Title: 3rd Response to OCC Highways Comments

Date: July 2022

- 1.1 Jubb has been commissioned by Hallam Land Management Ltd (HLM) to provide highways and transportation advice in relation to proposals for a residential-led mixed use development on Land north-east of the railway line in North West Bicester (Hawkwell Village).
- 1.2 This technical note sets out, in table format at **Appendix A**, a response to Oxfordshire County Council's transport and highways comments relating to TN05 '2nd Response to OCC Highways Comments' submitted to support the planning application 21/04275/OUT.

Appendix E: Drawing 20300_SK_T_001_P3

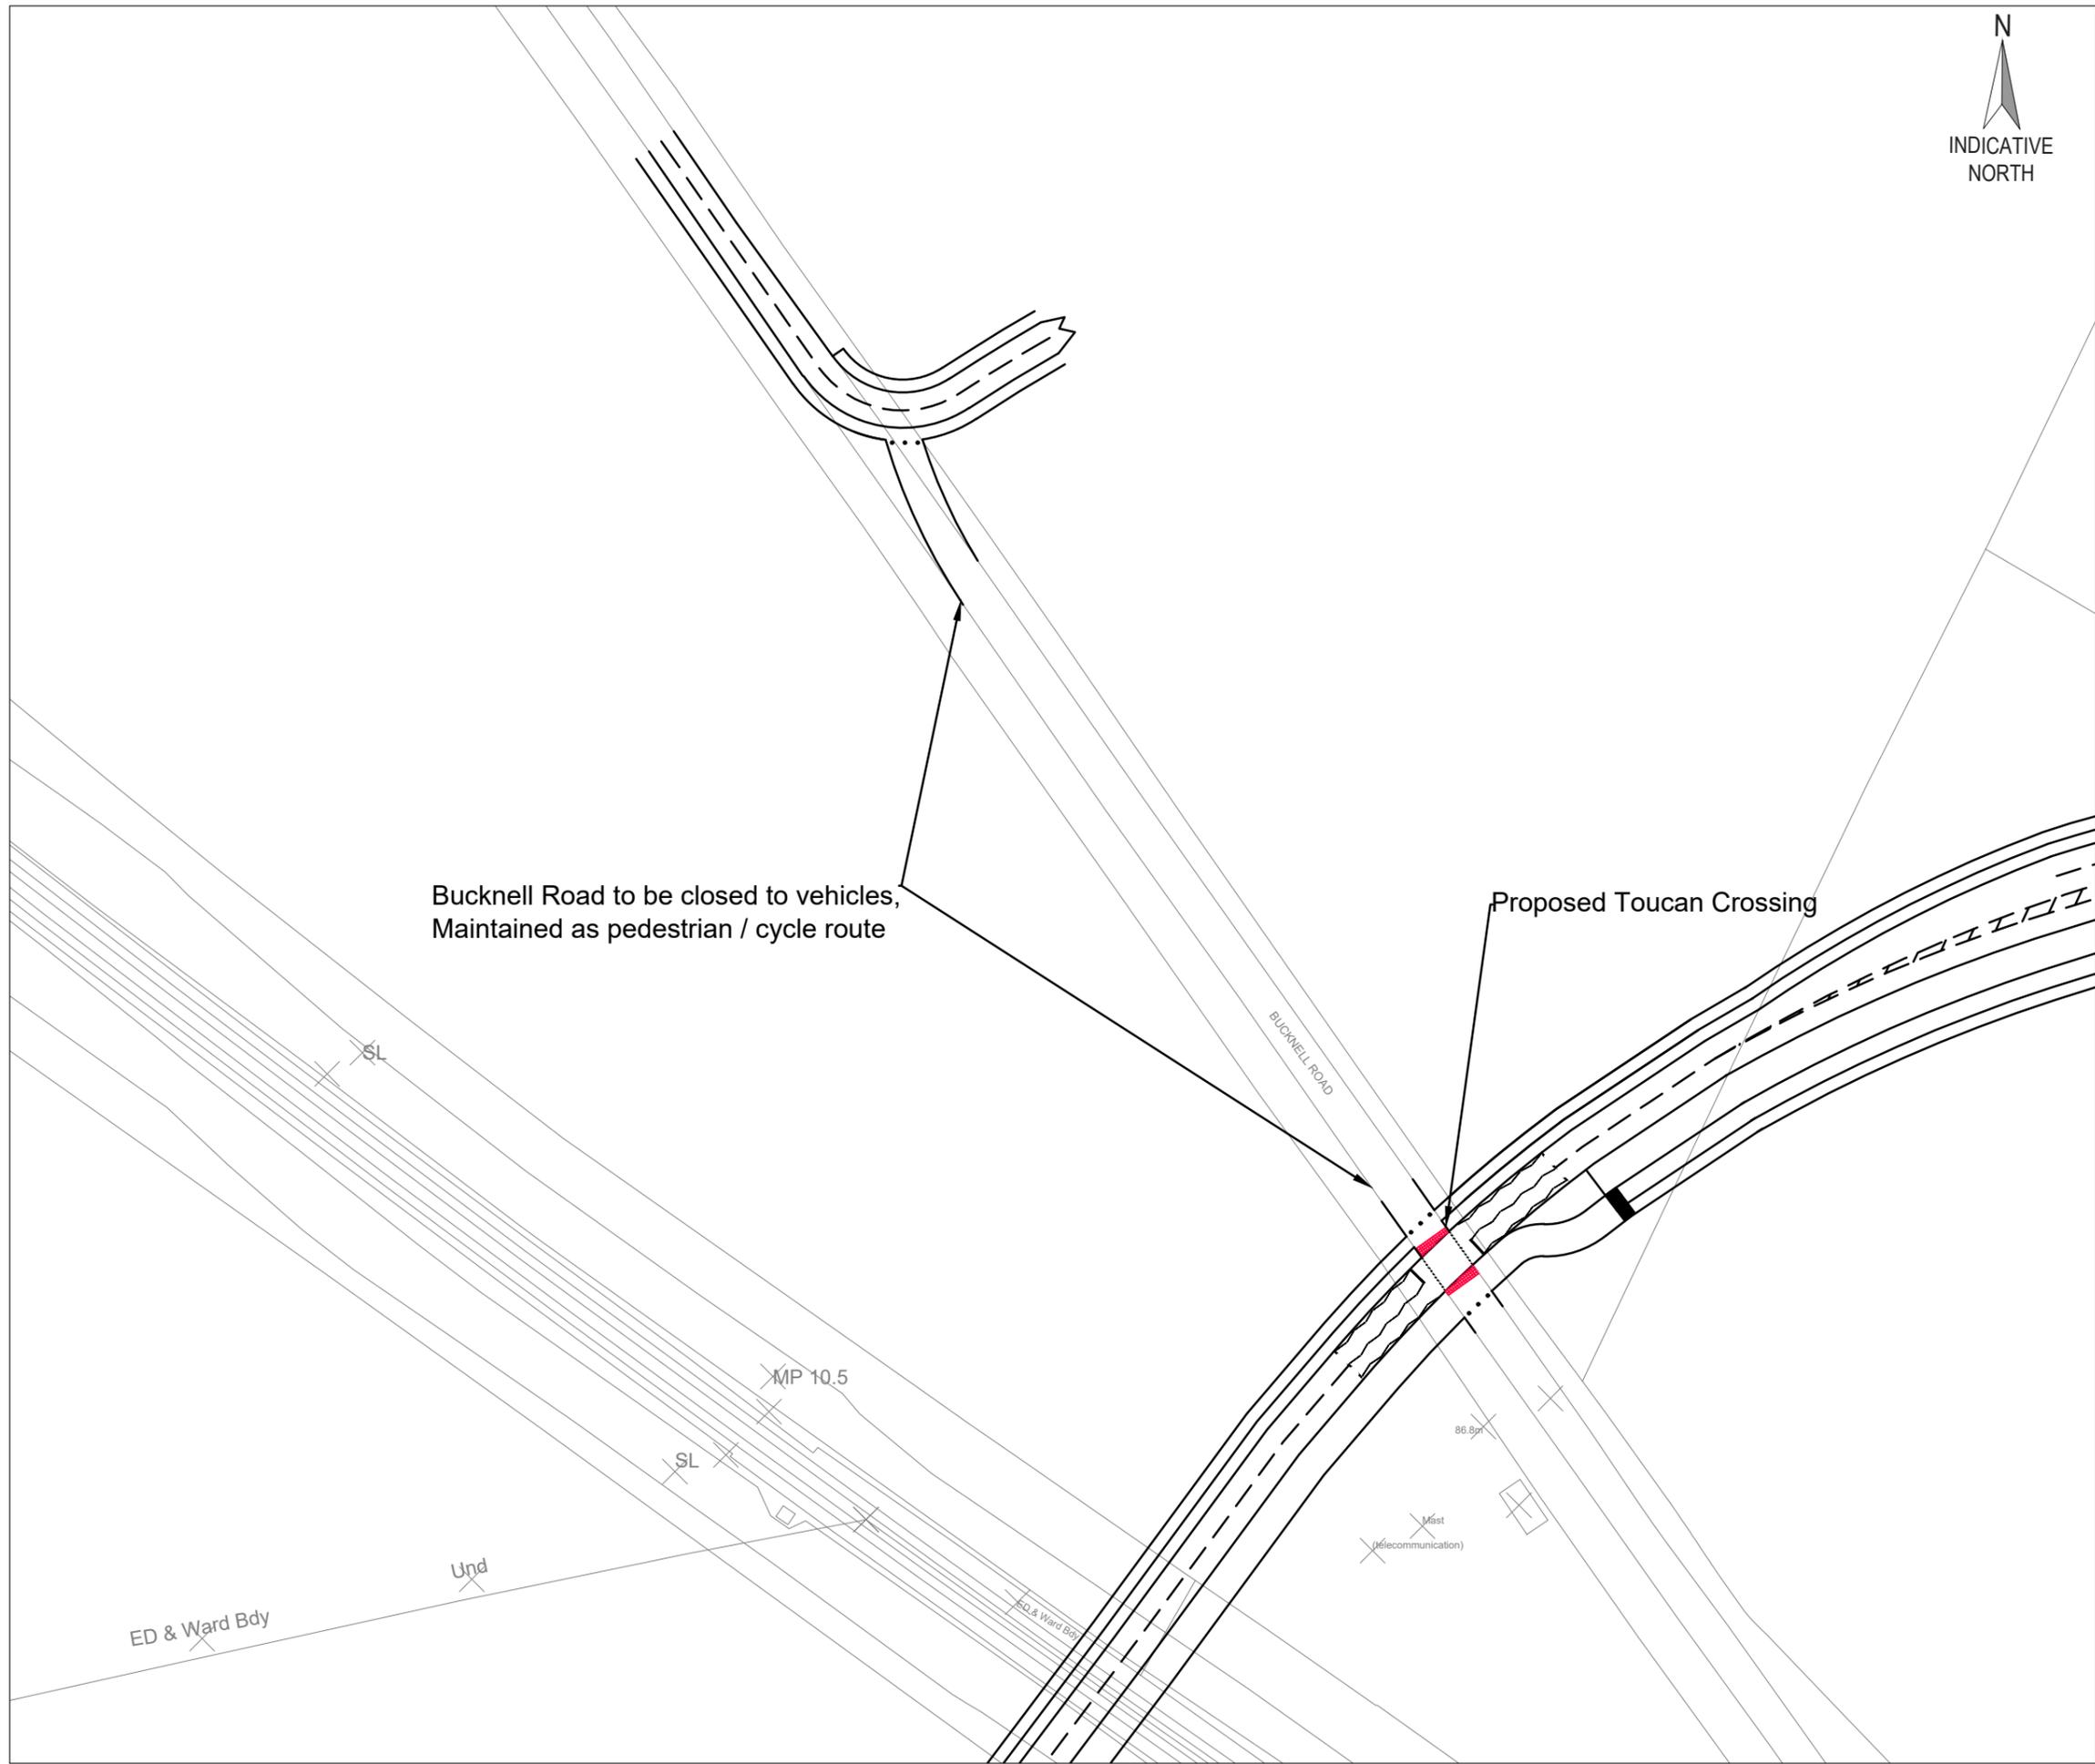
Appendix E	Main access off Lords Lane. Ditto. 3m shared use path is no longer adequate. Is two-lane approach from the site necessary? Segregated cycle facilities required on both sides of the road within the development - compliant with LTN 1/20. See general comments re this junction above.	Noted. Design to be amended. The Lords Lane site access forms part of the Primary Street identified on the framework plan and will therefore, be comprised of the components as shown in the cross-section at Appendix A .						
Appendix F	See above regarding position of junction of secondary access into the site. The design of this junction needs to be considered in the context of other junctions onto Bucknell Road (for which details need to be provided). Cyclists along Bucknell Road should have priority. Link into GI route parallel to Bucknell Rd should be shown.	Junction positioning along Bucknell Road will be undertaken in accordance with OCC design guidelines. A link into the GI route parallel to Bucknell Rd will be shown.

Bucknell Road to be closed to vehicles,
Maintained as pedestrian / cycle route

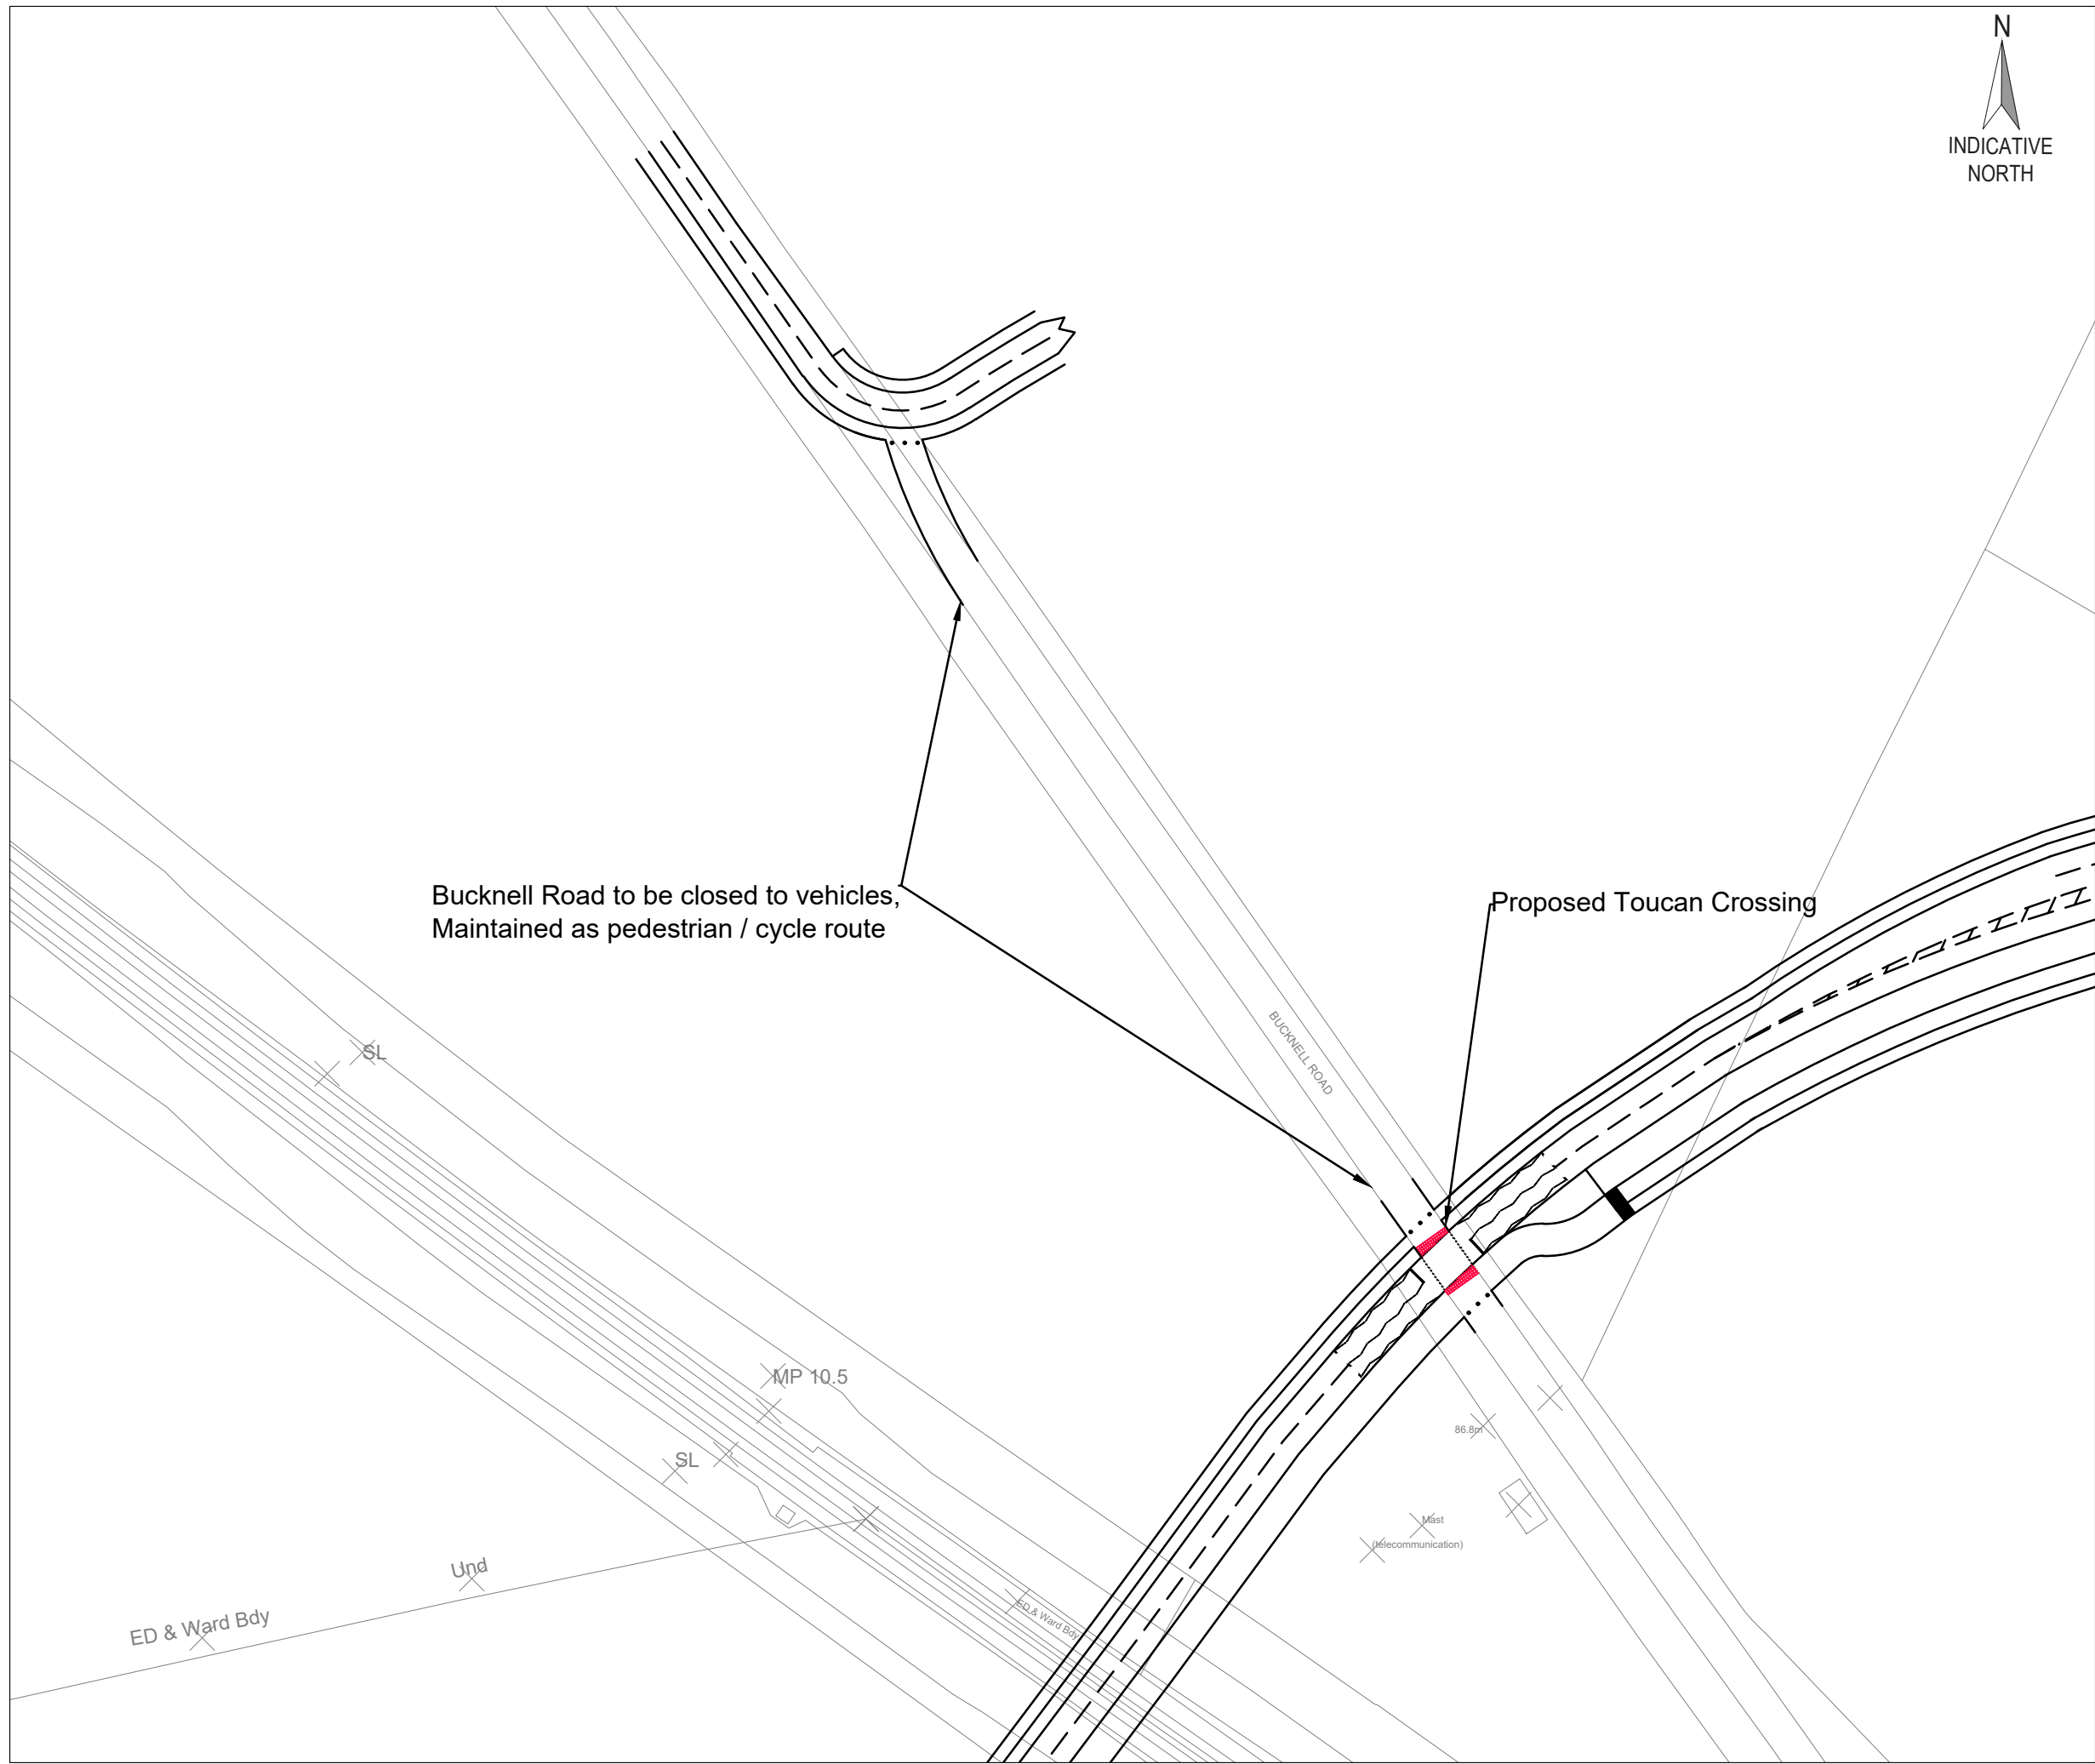
Fig 7.4	The secondary access onto Bucknell Road is too far south and therefore not in accordance with the Masterplan Strategy, which aimed to discourage through traffic from using Bucknell Road by offering a much less direct route through the development. See comments below regarding design of junction. Off site highway works would be required at the southern end of Bucknell Road where it joins Lords Lane, in connection with the restriction to pedestrians and cyclists only. A TRO will be needed to close this section of Bucknell Road to traffic.	With a combination of highway design and traffic calming and traffic management measures along Bucknell Rd journey times to Bucknell village will be increased, hence reducing the attractiveness of this route. Discussions are ongoing with Bucknell Parish Council regarding the exact nature of these measures. Noted and agreed.	Please provide details of meetings and progress with discussions.	Public meeting held on 14.03.2022 where traffic calming proposals for Bucknell Road and Bucknell village were presented (see Appendix B). A response to the parish council's queries has been provided.
